Our ref: Demolition of existing structures and construction of 3 X RFBs at 300 Burns Bay Road, Lane Cove (SSD-87925706)

26 May 2026

Subject: Request for Information

Figure 2.7 – Level 2-6 plan

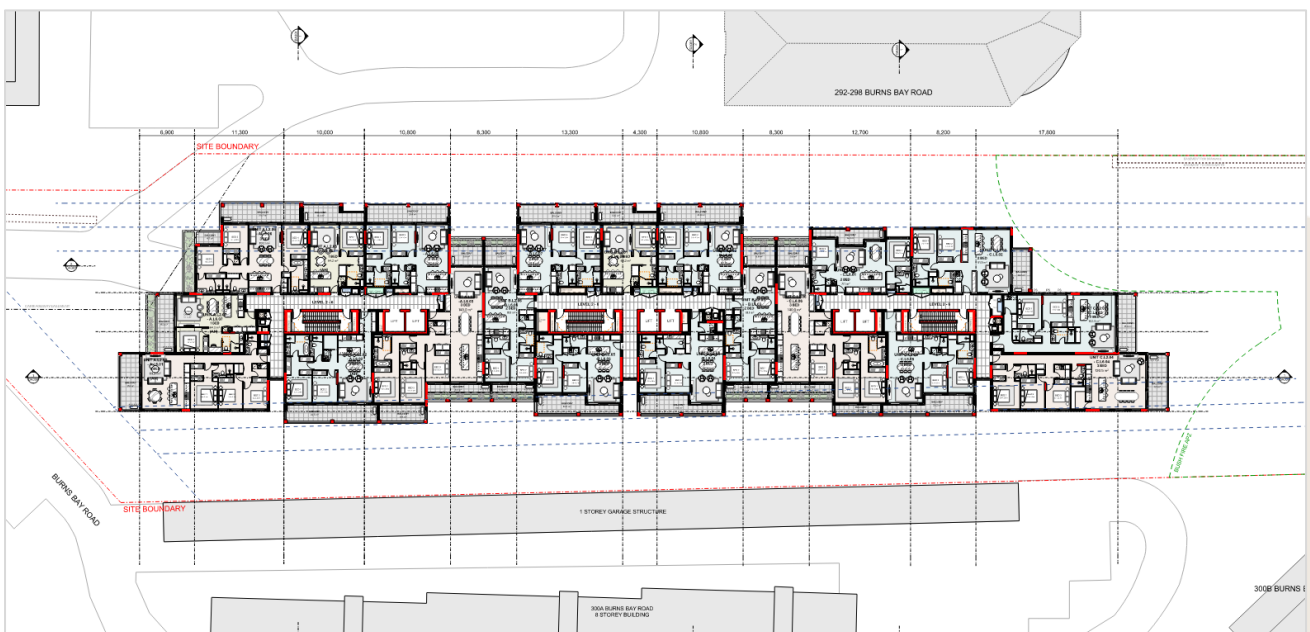
While the proposal states that the minimum required number of naturally ventilated apartments has been achieved, the architectural plans and supporting analysis are unclear as shown below under Image 1.

Several apartments appear capable of achieving natural cross ventilation, but this is not clearly shown in the submitted documentation. The documentation also does not include airflow arrows or sectional diagrams demonstrating cross ventilation outcomes and detailed plans to depict the inlet and outlet opening sizes, consistent with Figures 4B.3 and 4B.8 of the ADG.

- a) Amend the architectural floor plans to replace the existing blue dot notation with airflow arrows demonstrating natural ventilation paths consistent with Figure 4B.8 of the ADG.
- b) Additional plans depicting the Inlet and Outlet openings and area size as per Figure 4B.3 of the ADG.
- c) Submit amended plans and supporting documentation clearly demonstrating compliance with Part 4B of the ADG.
